Project: Sandstone Precinct

Subject: Re: DA Condition B7a - Nib Wall Pack

SHEET (2)

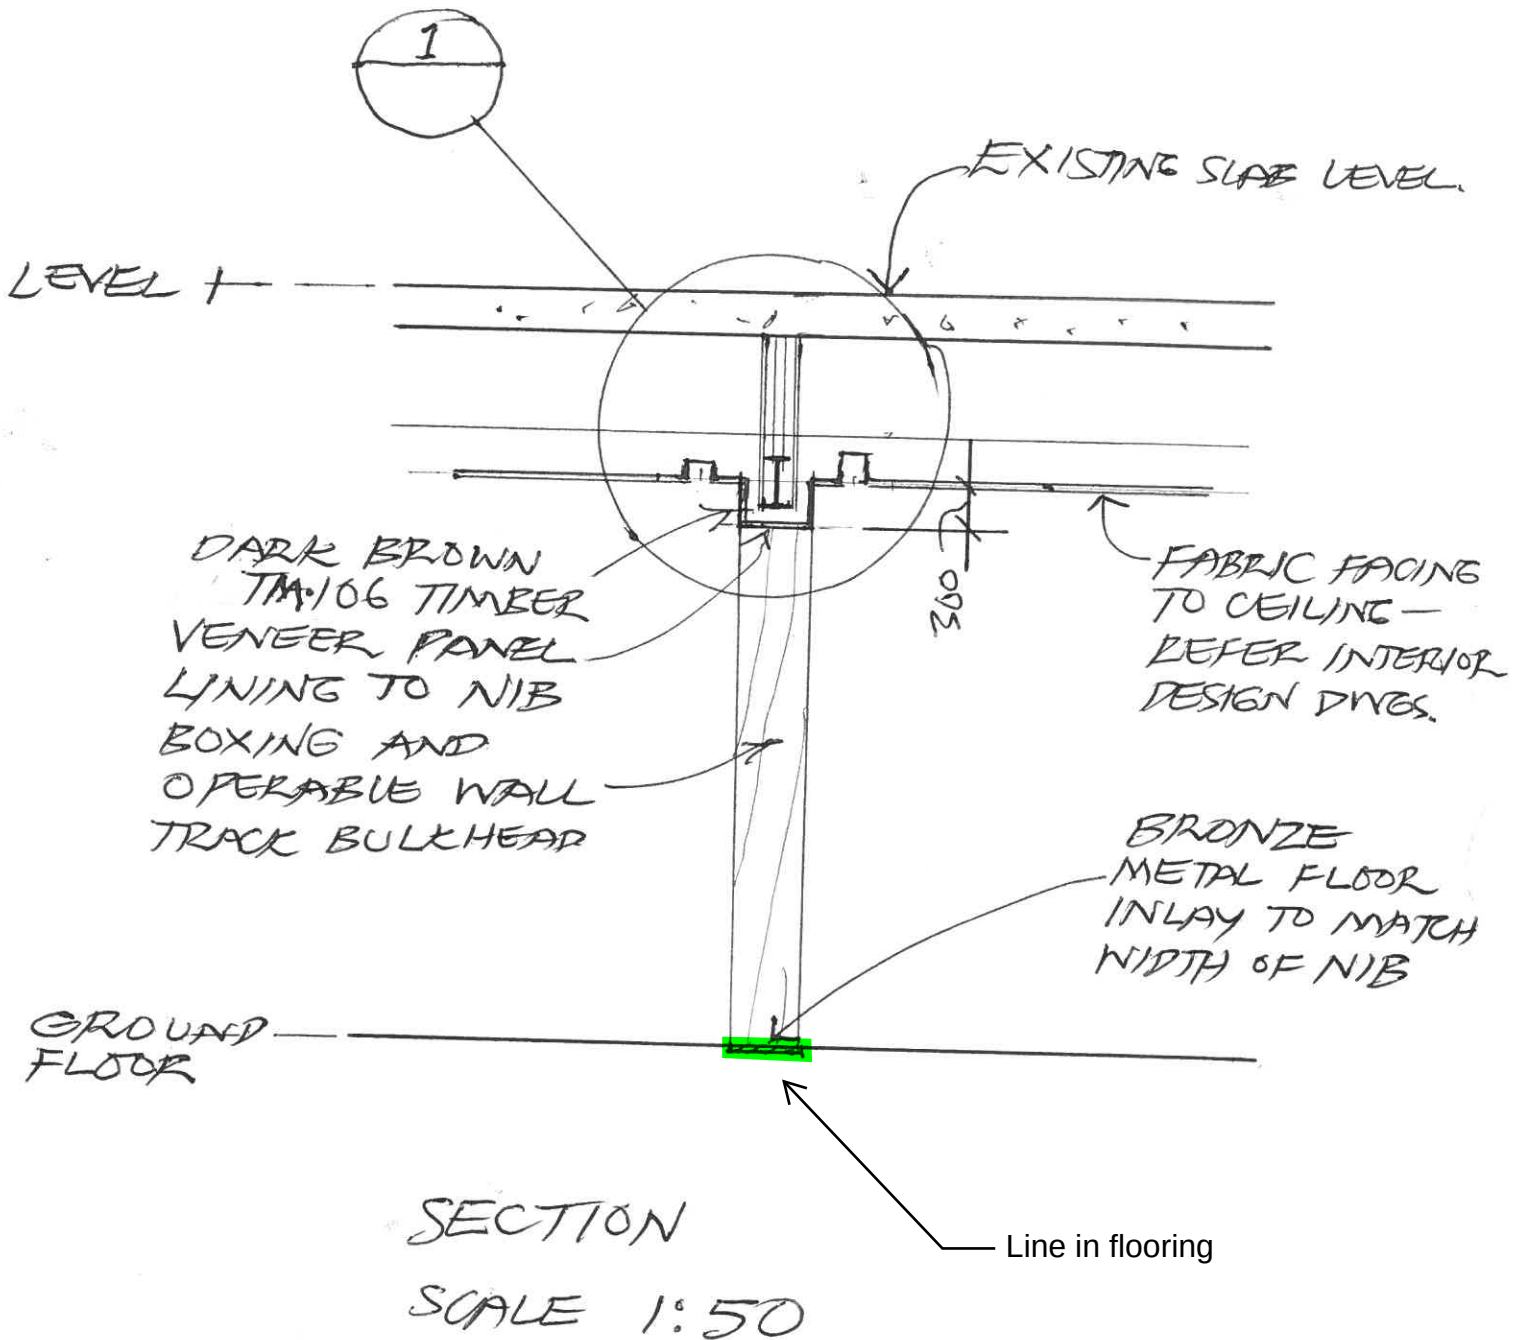
Further can the plans clearly show, via labelling, the line in the flooring and the substantial wall nibs and head.

SECTION DETAIL

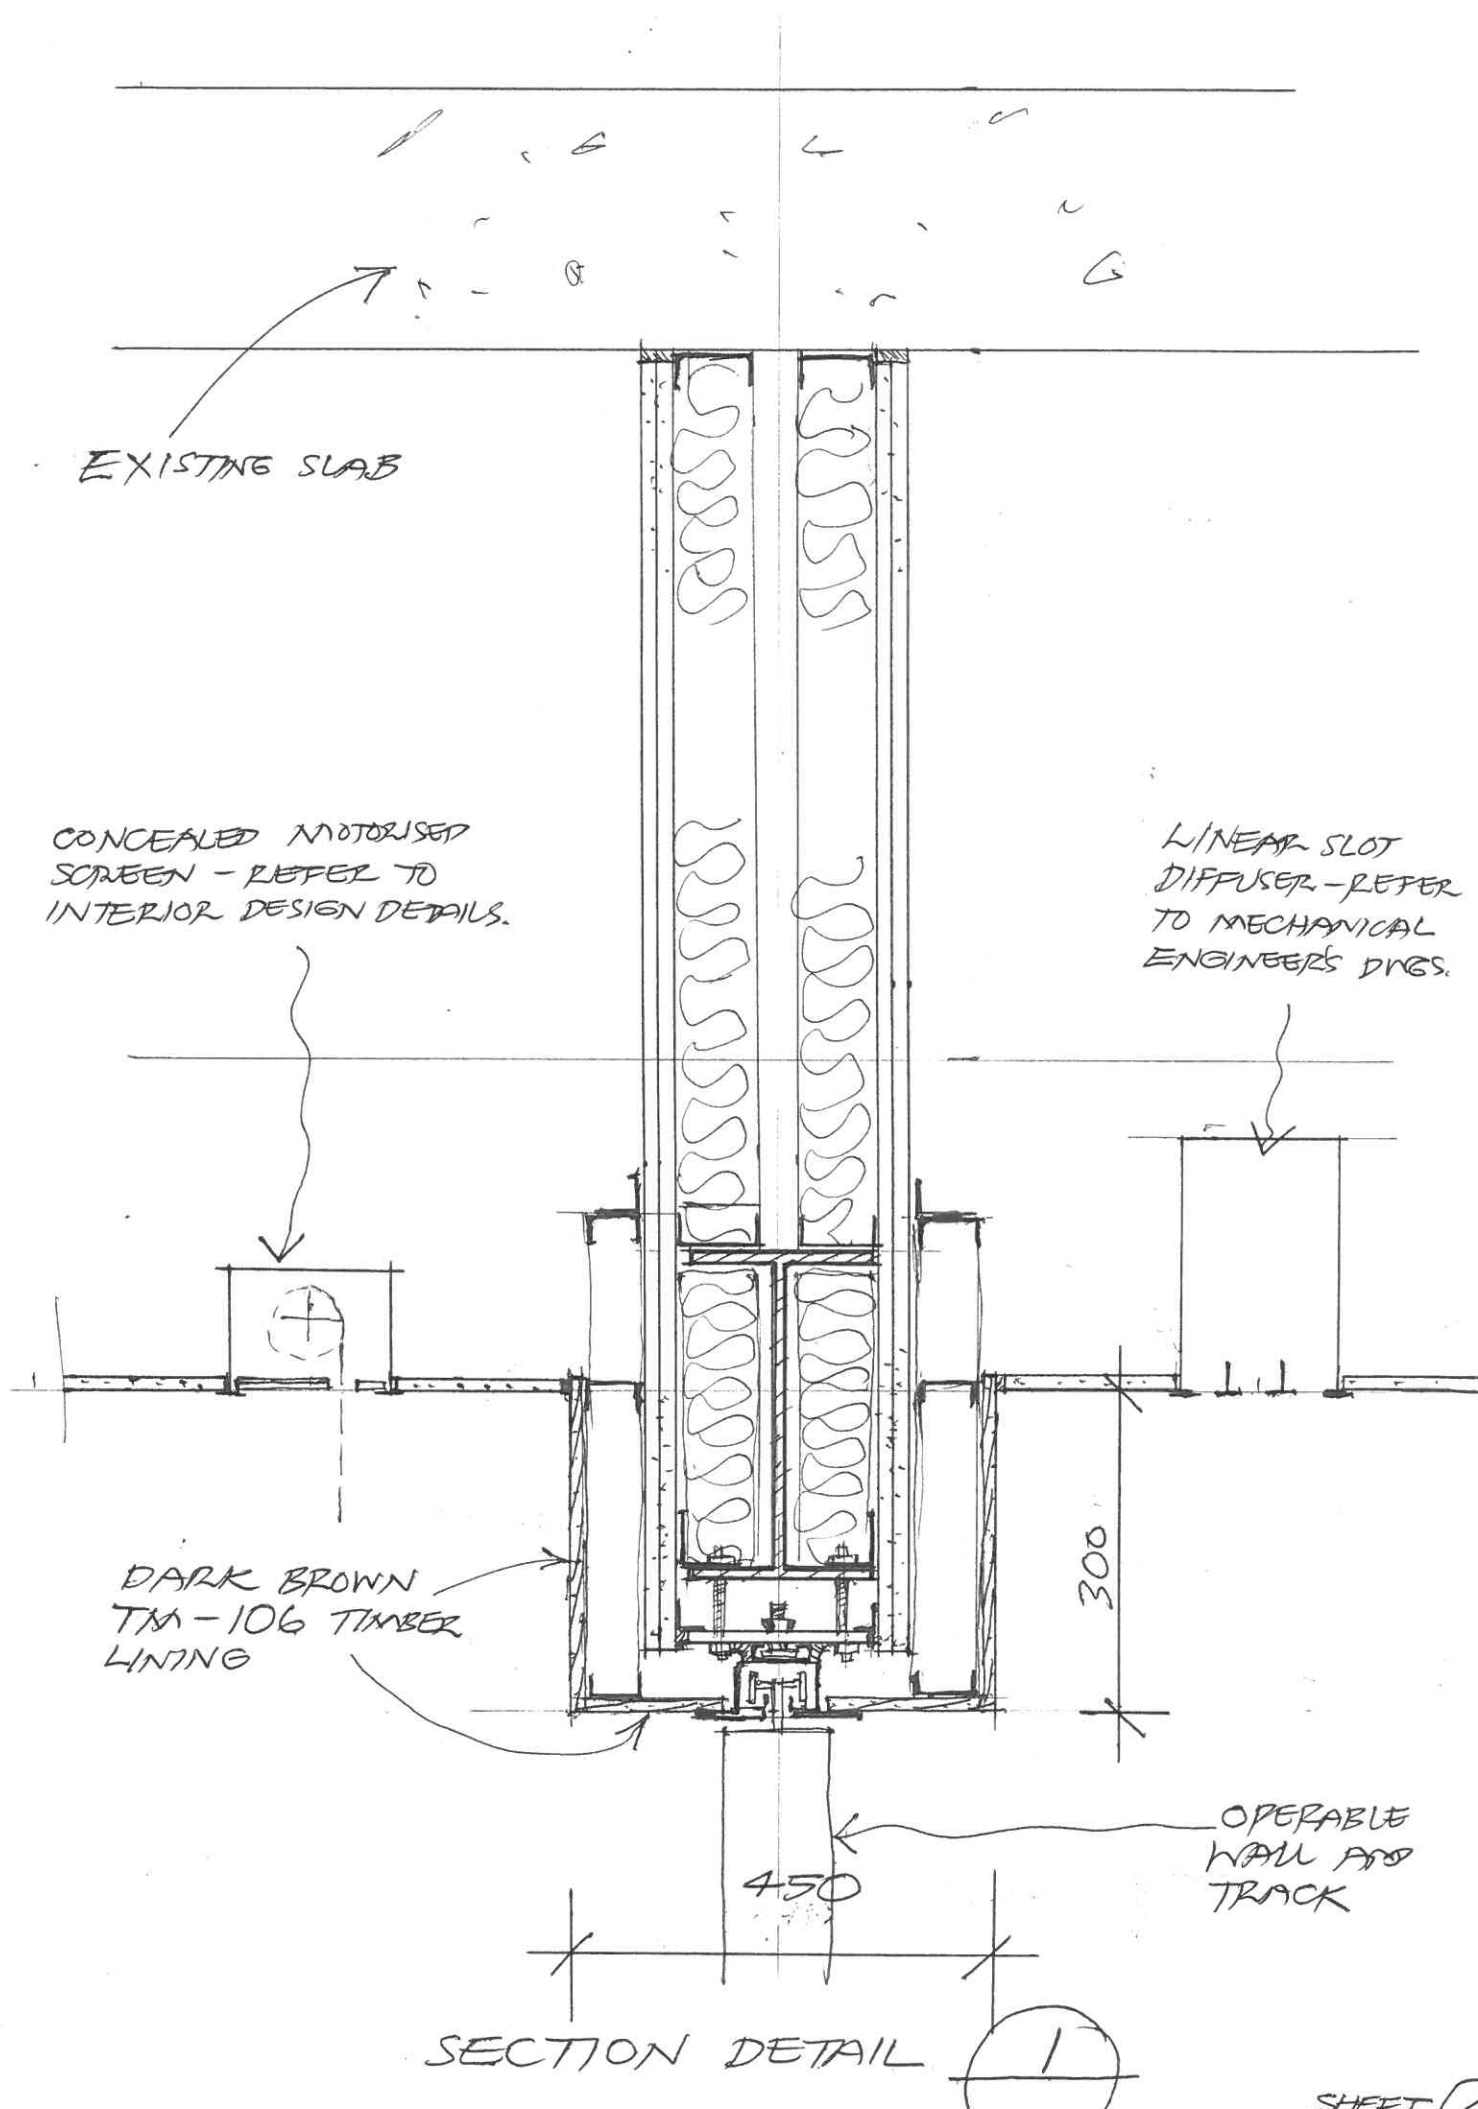
A detailed section through the operable wall would explain this detail.
